Application: SSI 7485

I write regarding the proposed modification to M4-M5 Link, Mod 2 The Crescent overpass and changes to pedestrian infrastructure in North Annandale, Rozelle and Rozelle Bay Foreshore area.

Figure 4-2 Pedestrian and cyclist bridge infrastructure options

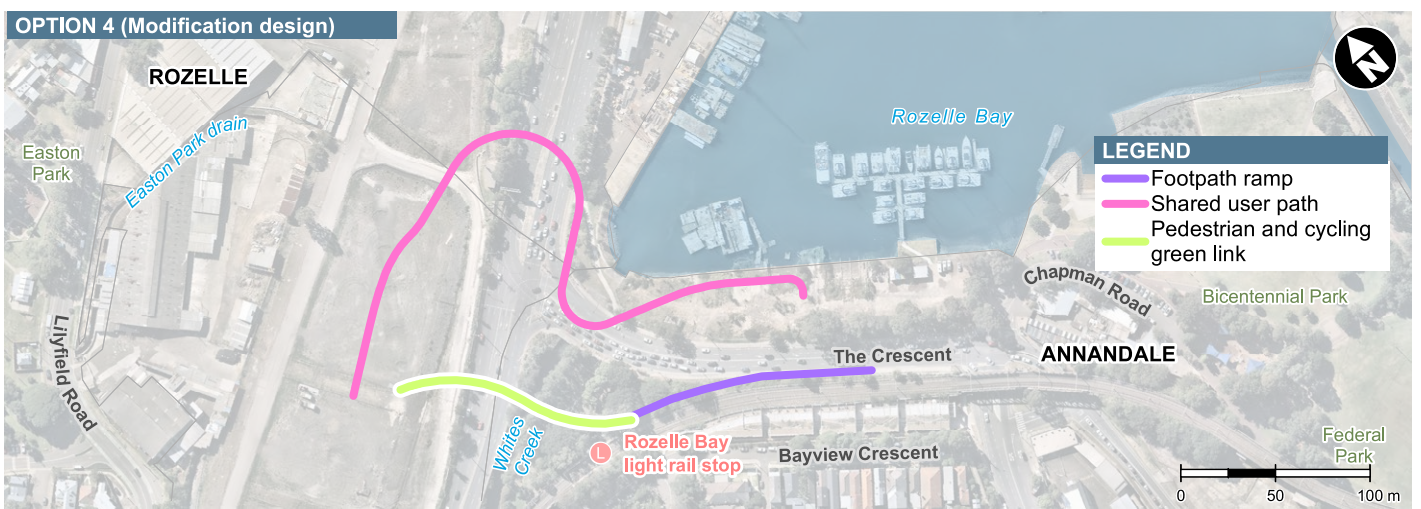
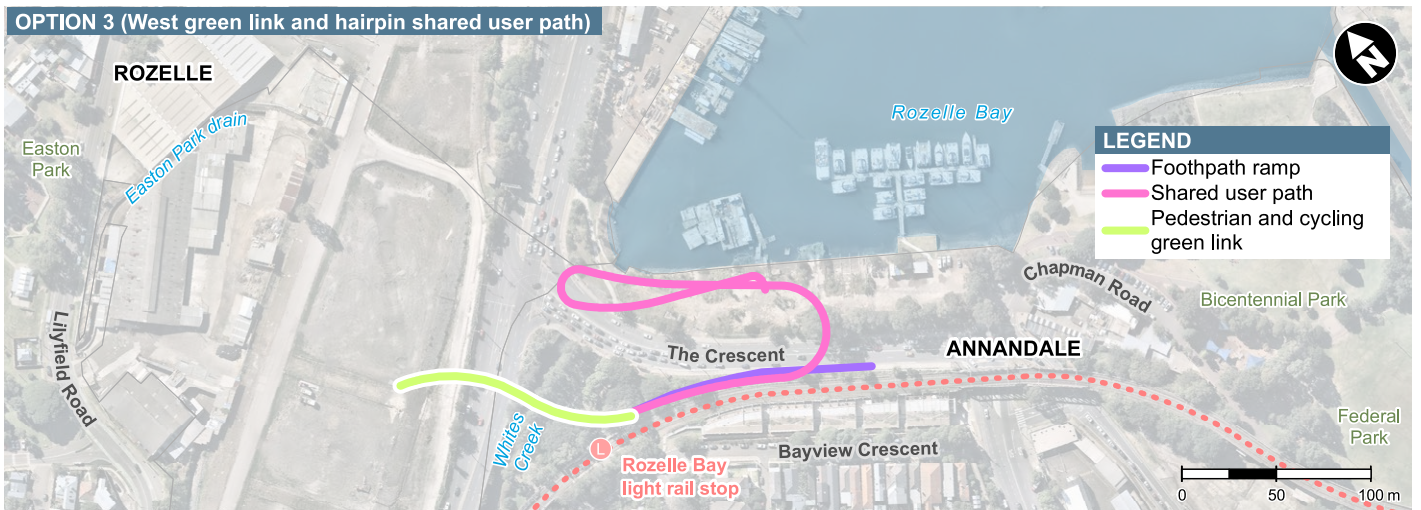
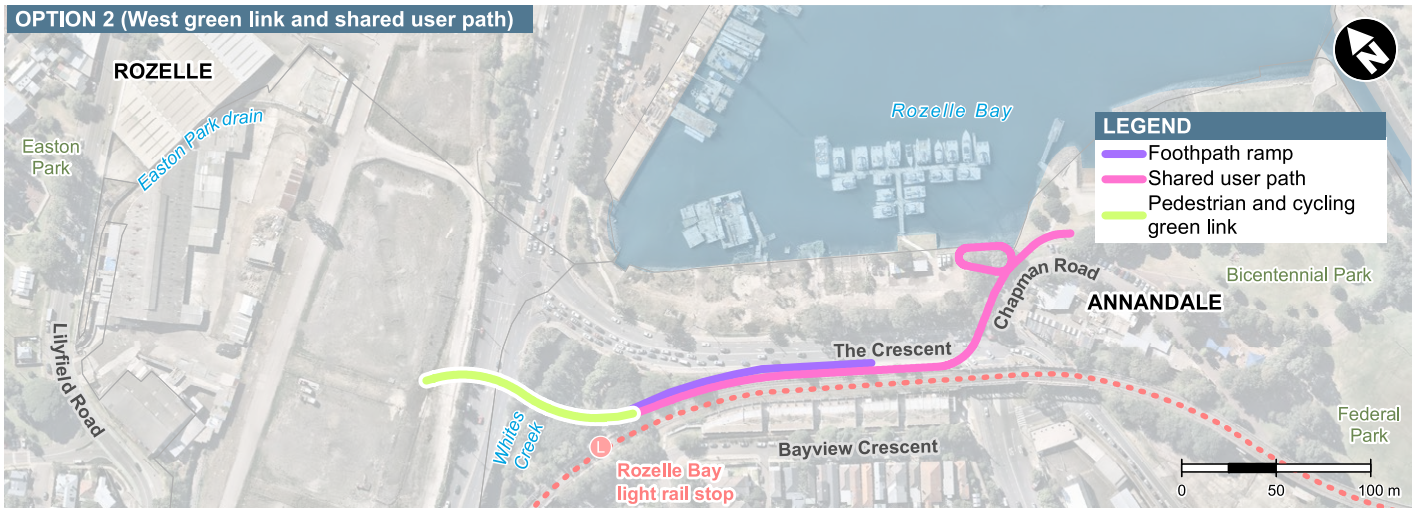
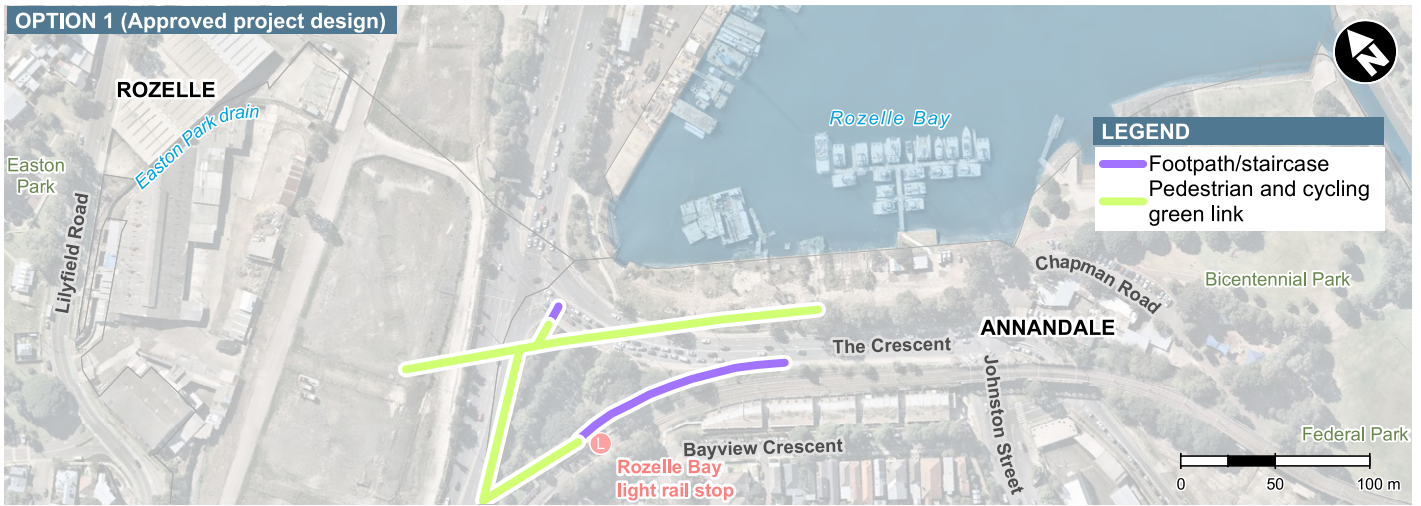
I request RMS work with the community to explore alternate design options to the proposed new car overpass design and the changed pedestrian and cyclist links. I am seeking the reinstatement of the safe, direct access from the approved EIS GreenLink to create a continuous green open space connection from the Rozelle Rail yards and Annandale to the foreshore. The GreenLink was more than just a walk way - it put people central to the design, maximising safety, and providing much needed accessible open space for the community now and into the future Bays Precinct design.

- The significantly reduced safety and increased risk for pedestrians and cyclists with removed access over The Crescent to Bicentennial Park and the increased traffic along Johnson Street.
- Being required to cross five sets of pedestrian lights at The Crescent as my option to reach the foreshore from Annandale or from Rozelle light rail stop.
- Removal of direct active links to the foreshore, cutting the community off from the area and the proposed revitalisation of the entire Bays Precinct, including linking the Light Rail and Bus stops to a Ferry wharf and Metro station.
- Urban and landscape design that is being built before a finalised Masterplan for the area.
- Traffic changes that limit movements around the suburb and create further congestion in the local streets of Annandale, Forest Lodge, Glebe, Lilyfield and Rozelle with no planning to deal with these.

- Reinststate the GreenLink connecting communities and green open space from Rozelle to Bicentennial Park.
- Relocate and design pedestrian and cyclist connections that are continuous, safe and direct.
- Design the modification infrastructure and active links in response to the character of the suburbs, the location of the foreshore and it's potential future development.
- Provide pedestrian and cyclist paths that maximise people safety and do not force us onto busier streets, unsafe concrete plazas and caged walkways.
- Integrate active and direct connections to all active transport – including the future Metro West and Foreshore Ferry Wharf.
